Colorado Springs, CO

Final Report - Corrections Required **Application No. LUPL-25-0008**

Document Filename : 241010_BLR Village C Land Use Plan.pdf

BANNING LEWIS RANCH - VILLAGE C

P:\2024\24-1010_BLR_Village_C\Drawings\241010_BLR_Village_C_Land_Use_Plan.dwg 6/13/2025 10:27 AM

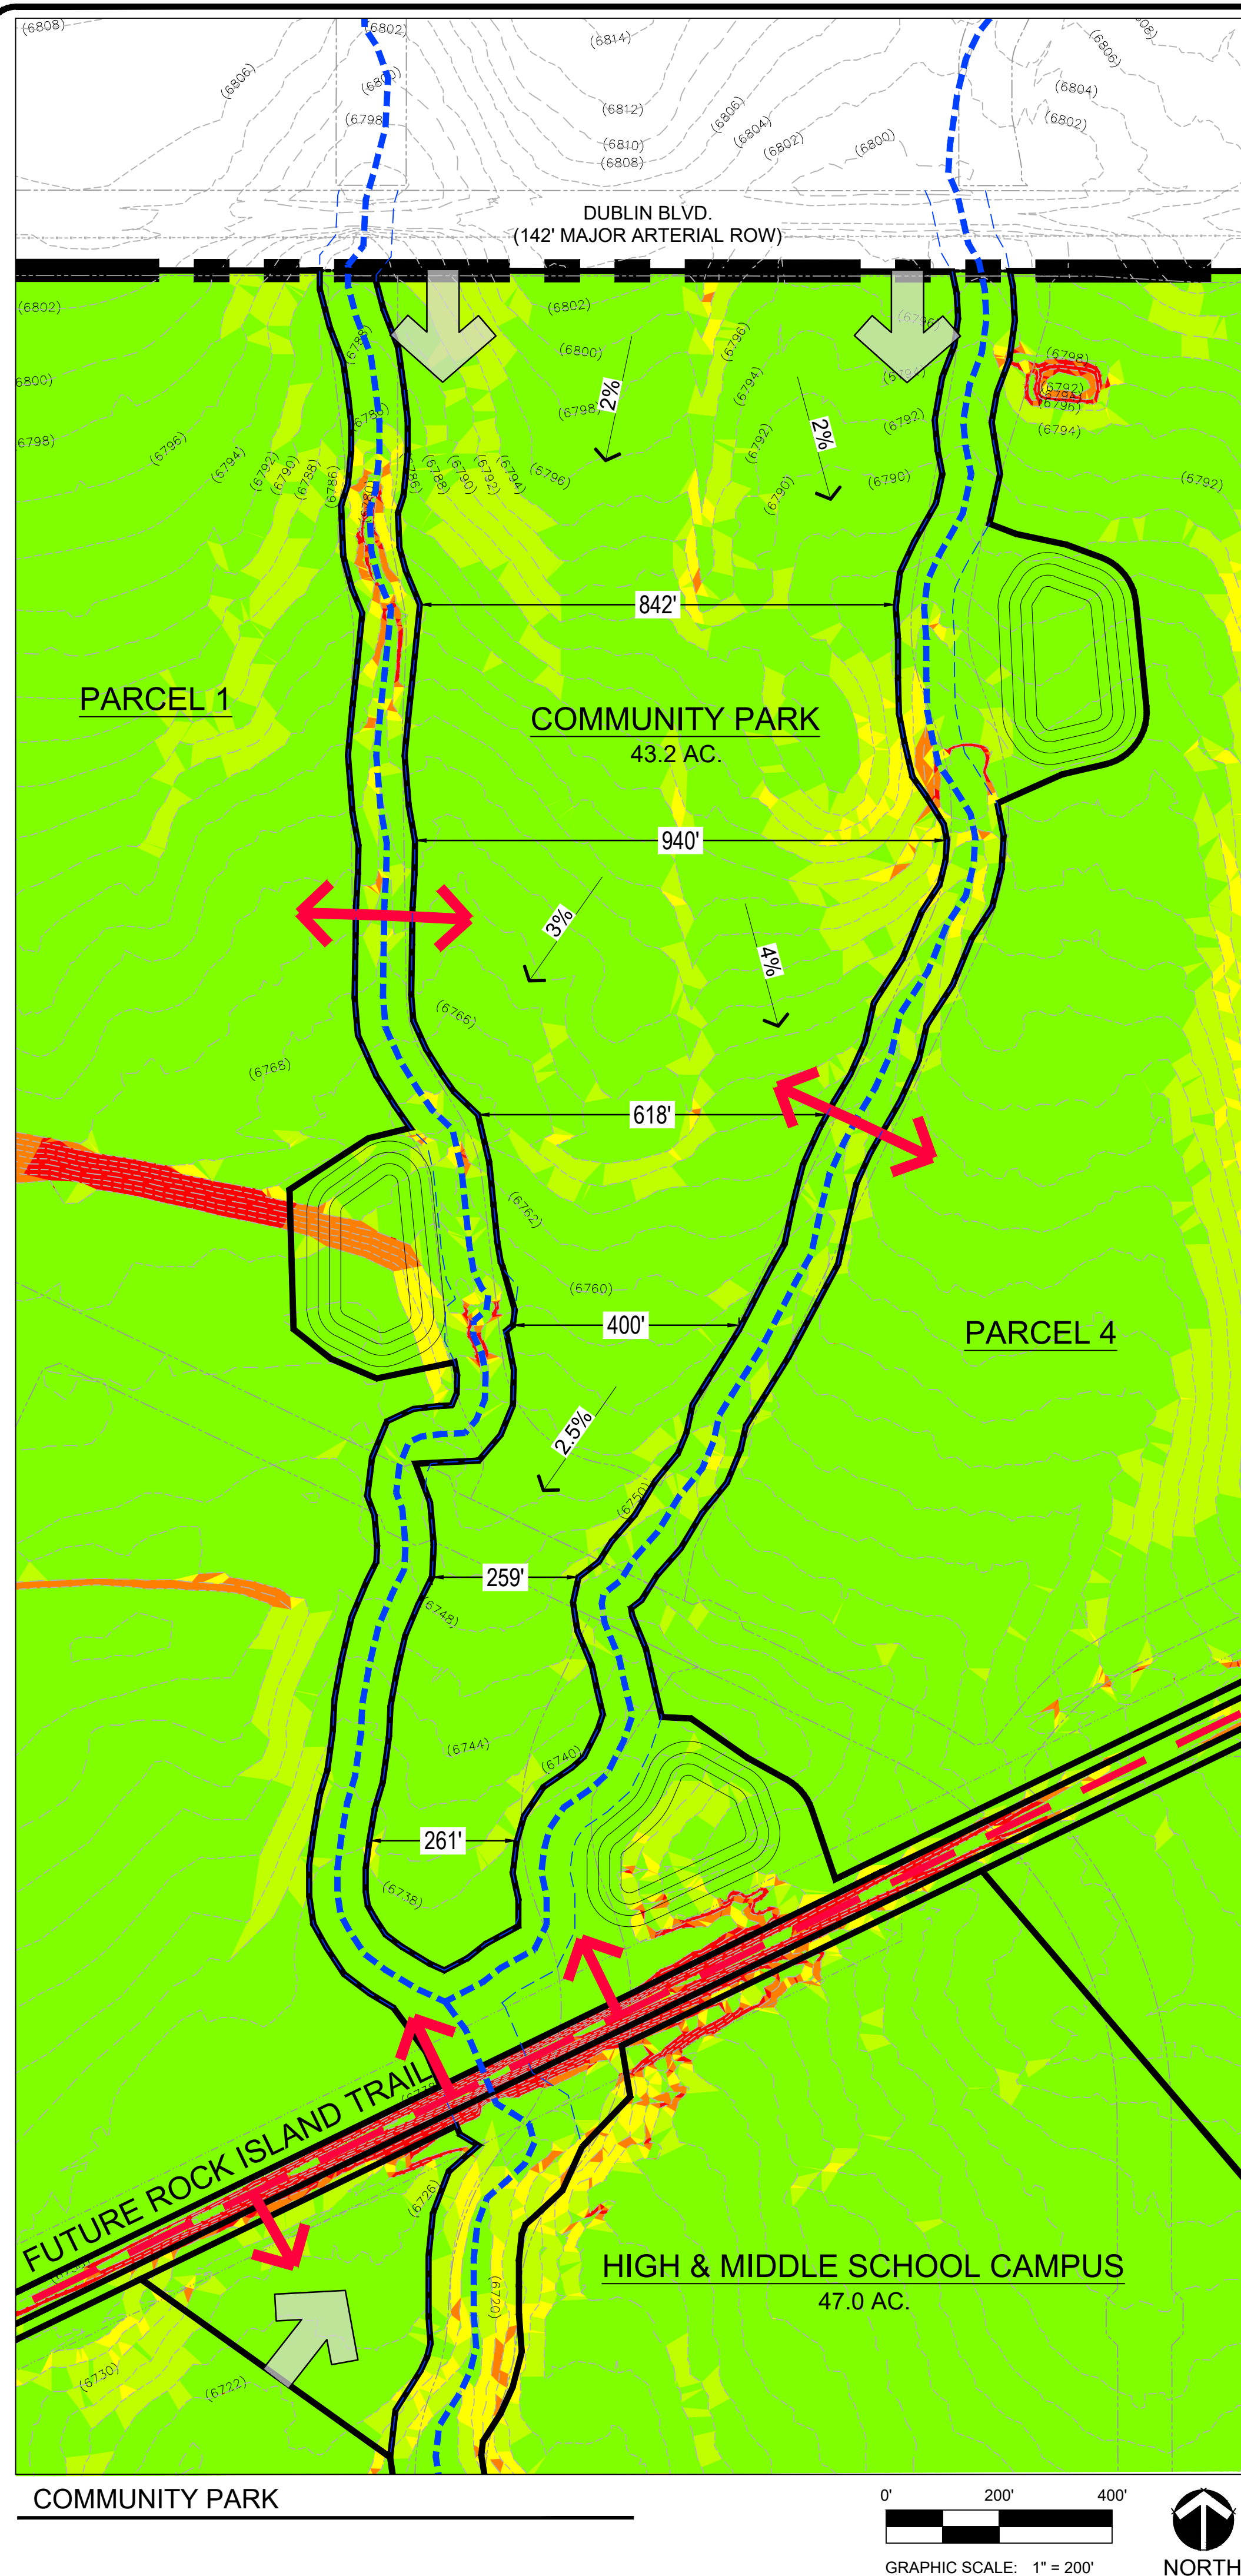
Comment ID	Page Reference	Reviewer : Department	Review Comments
16	2	Caroline Miller : Planning	Informational - More Parks comments or edits are likely to be requested.
19	2	Caroline Miller : Planning	Please revise all proposed zones - PDZ for Parks and Schools is no longer proposed.
21	2	Caroline Miller : Planning	As shown, there is a need for pedestrian bridges to allow connection to the Community Park site. Will the developer provide those?
22	2	Caroline Miller : Planning	As communicated with the developer team, May 2025, BLR Village A is to be viewed as a separate development, removing the Community obligation of Village A from Village C. Please remove all references to Village A acreage. PLDO reviewer acknowledges that with this direction, the Community Park size is required to meet B2 & C obligations is 28.7 acres, though additional acreage would be supported in creating a larger, more versatile site, and better meeting Community Park Site characteristics.

23	2	Caroline Miller : Planning	Please add Village B2 Community Park acreage to table, as it is carried over from Village B2.
24	2	Caroline Miller : Planning	Please recalculate math for Community Park obligations for Village C and B2. Reviewer calculates 11.568 for Village C and 17.128 for Village B2 with units shown.
26	2	Caroline Miller : Planning	Please confirm, in prior LUP Review (PDZL-24-0005) 1,841 units were used as an average for PLDO calculations. Now, this number has been revised to 1,446 to account for 6 du/ac (Note 1) where the mean unit count is now 2,285. Please confirm with staff which count is more accurate. Typically staff would go with average.
28	2	Caroline Miller : Planning	Notes 2 and 4 need to be updated with accurate acreages and reflect that Village A is no longer included.
29	2	Caroline Miller : Planning	Staff sees 4 3.5 acre parks totaling 14 acres of Neighborhood Parks. Are there any notes that need to be added regarding the 4th park site considering future multifamily development? Is the intent that the future multifamily development will be meeting Neighborhood Park PLDO through this dedication, with Community Park fees in lieu due? Staff is supportive of the eastern 4th park site, as it is geographically separate from the rest of Village C and a benefit to the residents there.

32	2	Allison Stocker : Planning	Label creek name and type
42	2	Tamara Baxter : Planning	Refer to EPC, EPC Engineering and District 49 comments which were uploaded to file.
43	2	Tamara Baxter : Planning	Please see separate email dated 6.25.25 from City Budget Office sent separately.
44	2	Tamara Baxter : Planning	Single Family detached are conditional use in the MX-M zone district.
45	2	Tamara Baxter : Planning	Please clarify what is intended as "Mixed-Use", does this anticipate more than commercial and residential per UDC?
46	2	Tamara Baxter : Planning	Add the AP-O and SS-O overlays to the proposed zone district labels.
47	2	Tamara Baxter : Planning	Add the "SS-O" overlay to the proposed zone district labels
49	2	Tamara Baxter : Planning	Is this both detached and attached?
50	2	Tamara Baxter : Planning	This range does not include the proposed residential density in parcel 6, 7, 8 and 9.
52	2	Tamara Baxter : Planning	The UDC does not define Mixed-Use. Can you please clarify. Does this encompass the uses that are allowed or conditional in the MX-M zone district? Are there uses that you want to restrict?

53	2	Tamara Baxter : Planning	Please use this on the coversheet as well.
54	2	Tamara Baxter : Planning	What does this residential encompass?
30	3	Caroline Miller : Planning	This graphic doesn't match the LUP Bubbles shown on page 2, park is not next to Public Safety.

6

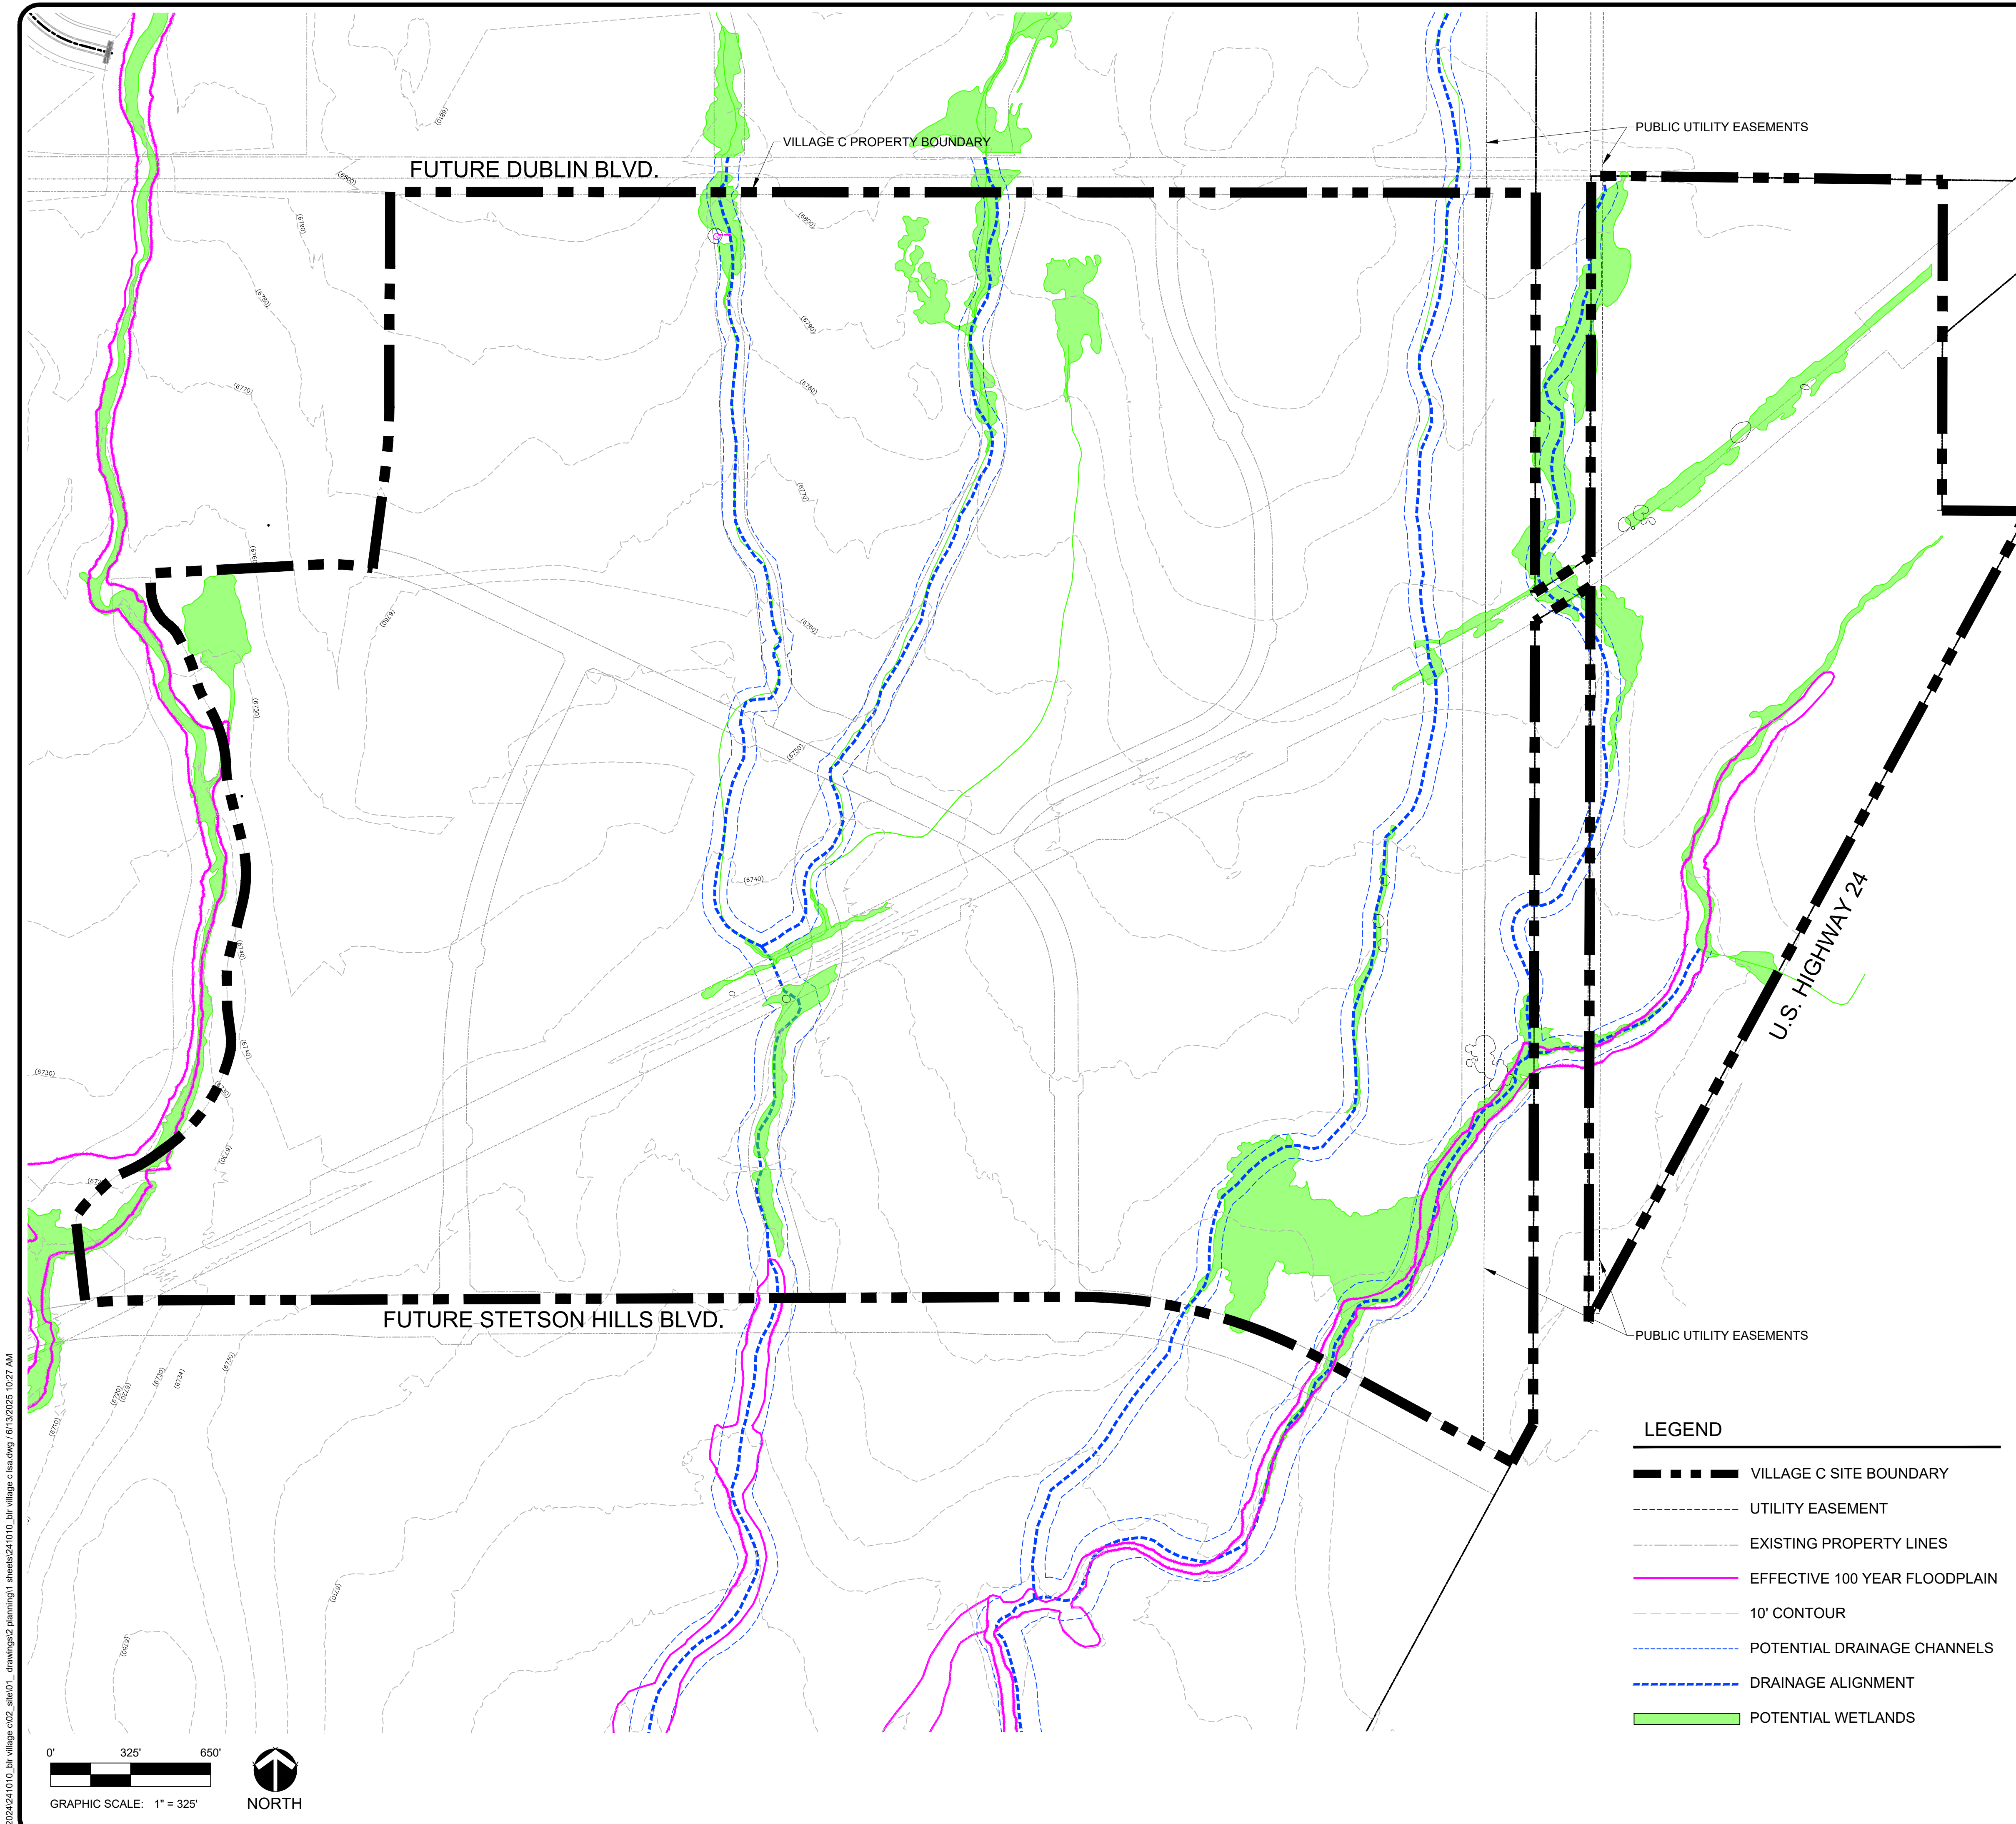
Comment ID	Page Reference	Reviewer : Department	Review Comments
33	4	Allison Stocker : Planning	Can the conceptual trail connections be shown to help staff get an idea of how that may look?
55	5	Tamara Baxter : Planning	Refer to the date of this plan...ie what version. Thank you for including.
4	7	Allison Stocker : Planning	label creek with name and type
25	2	District #49 : School Districts	PK-8 proposed
